**PLANNING APPLICATION CONSULTATION RESPONSE**

<b>Application Number:</b>	3/2024/0726
<b>Proposal:</b>	Approval of details reserved by conditions 4 (construction management/method), 5 (site access and off site works of highway mitigation), 11 (car park surface water drainage), 17 (surface water drainage) and 18 (surface water and pollution prevention) on planning permission 3/2020/0911.
<b>Location:</b>	Shackletons Garden Centre Clitheroe Road Chatburn BB7 4JY

**Lead Local Flood Authority Position**

Reid Jones Partnership drawing No. 10301-103  
Proposed Construction Stage Drainage General Arrangement

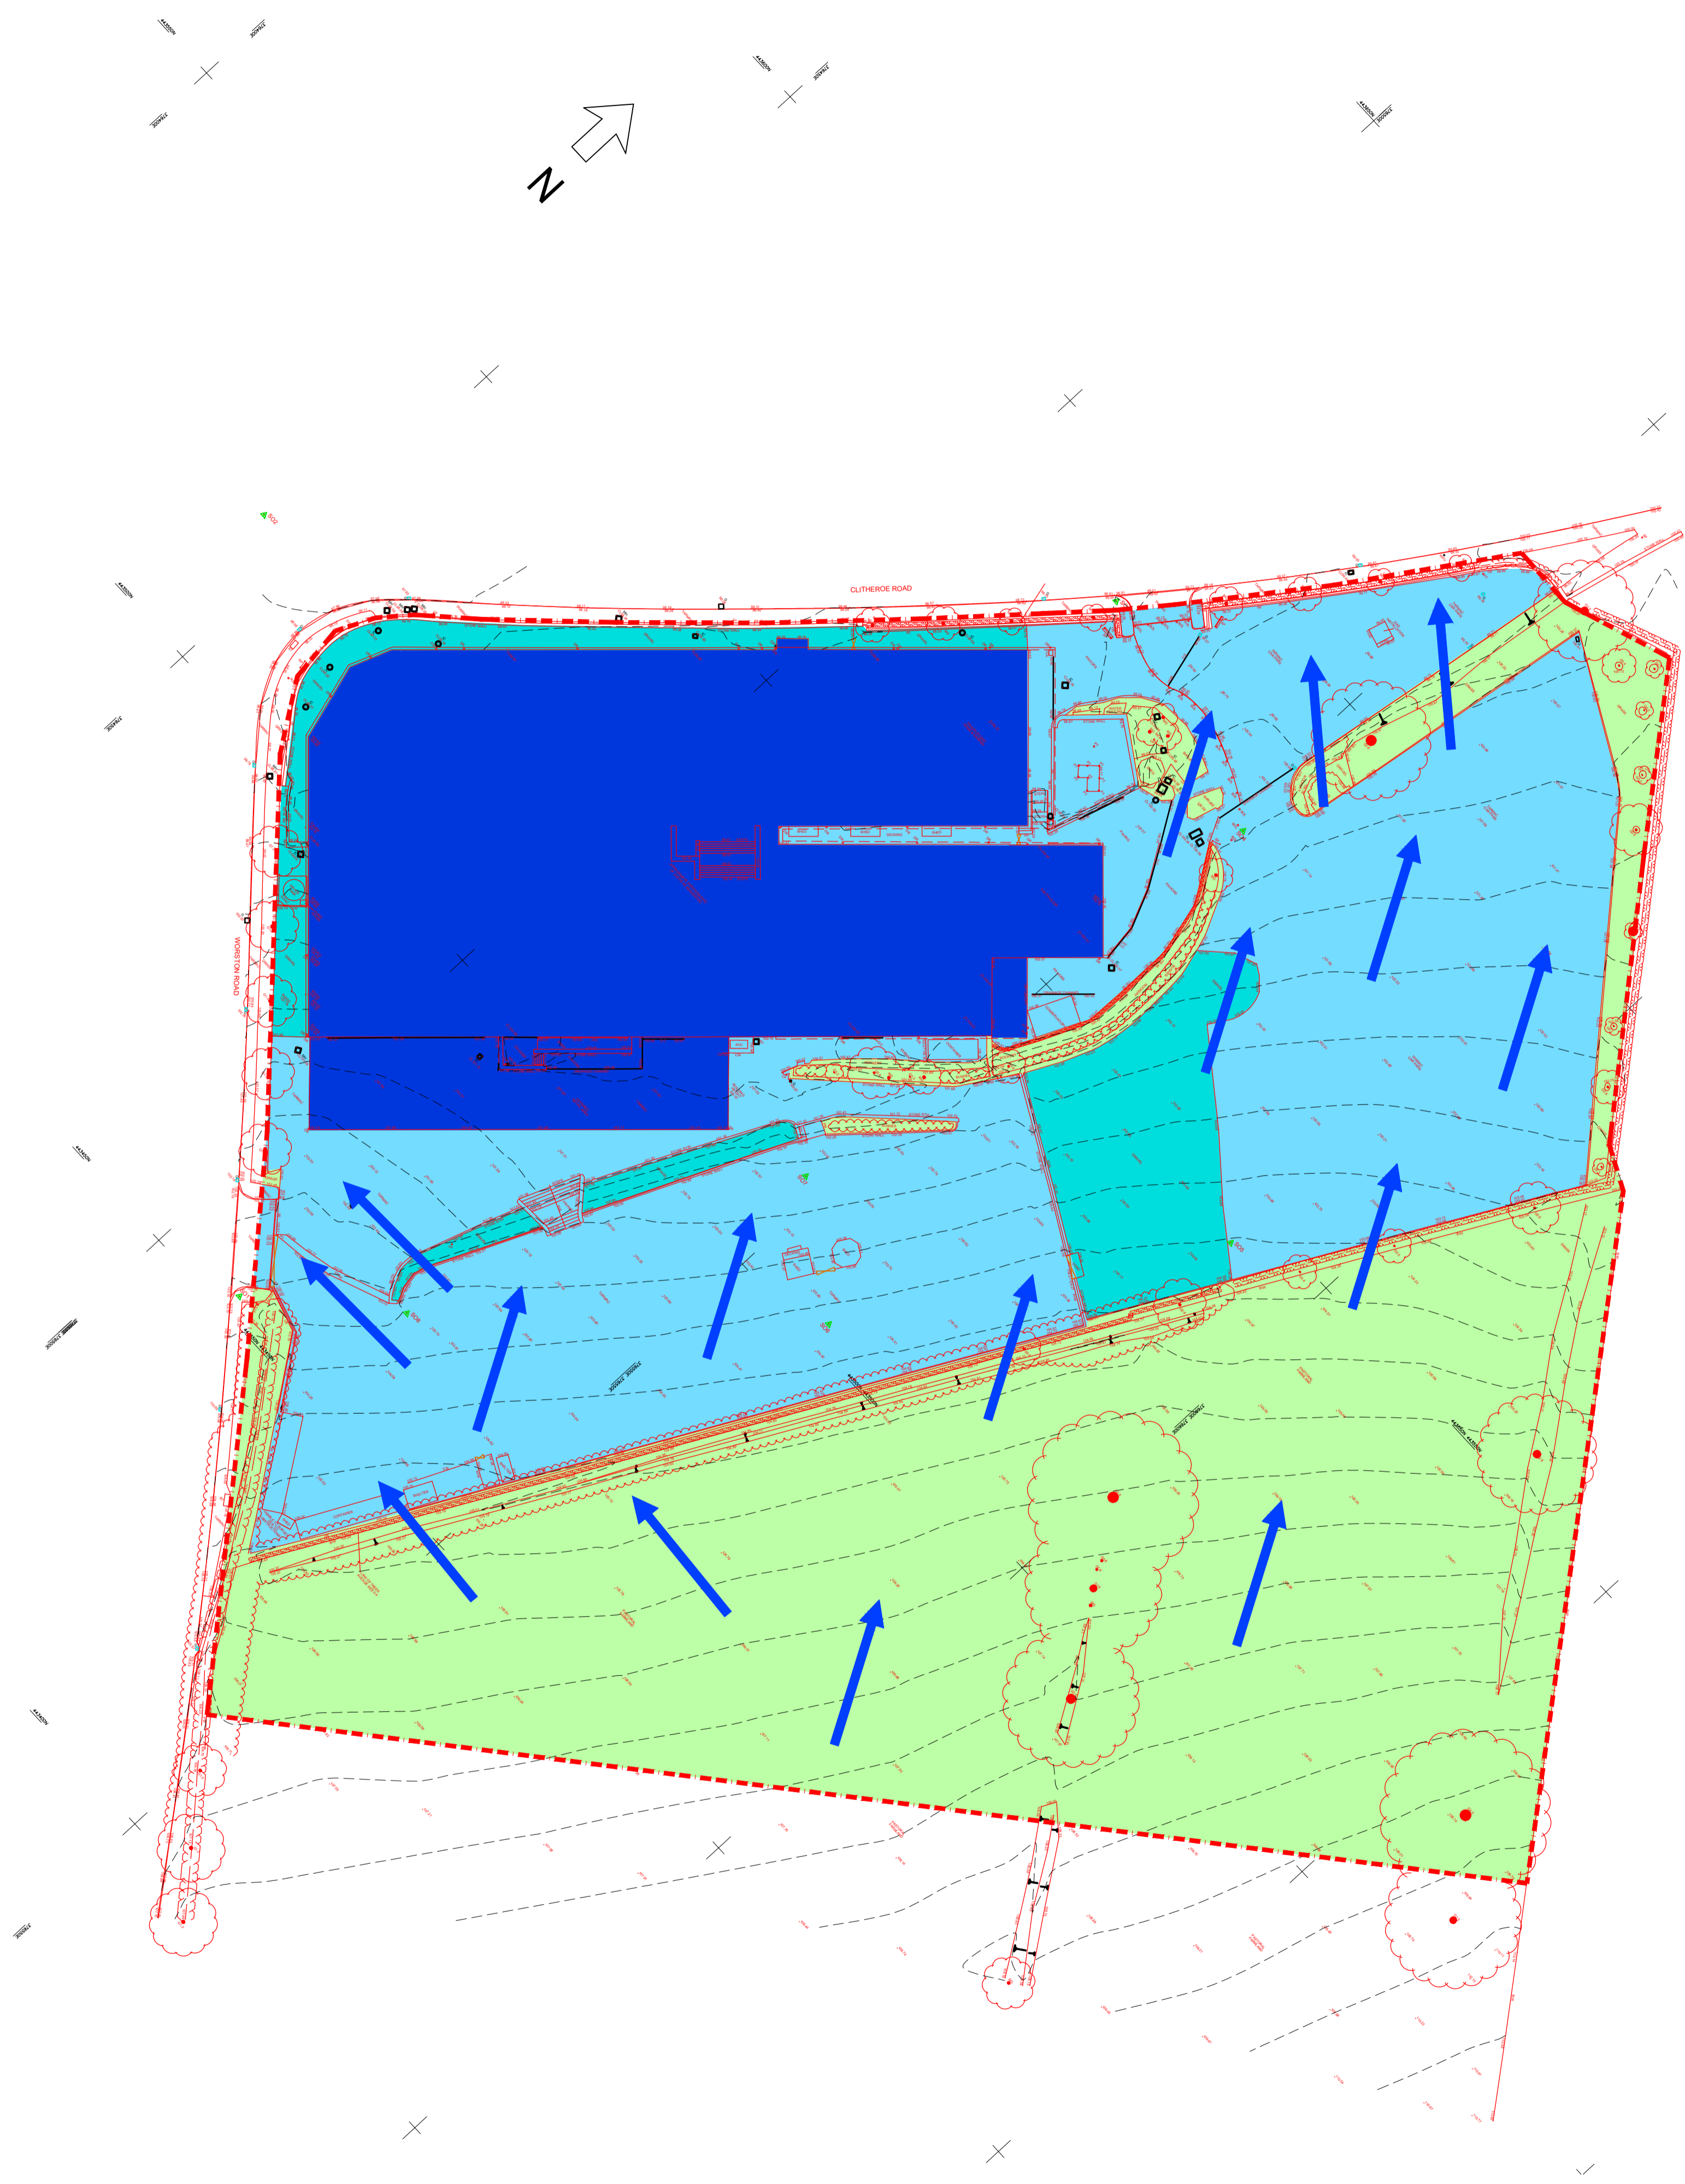
The applicant should ensure that surface water will be discharged from the temporary drainage system during the construction phase and the proposed settlement pond at a restricted rate, similar to that as the proposed discharge rate to the northern discharge location post development.
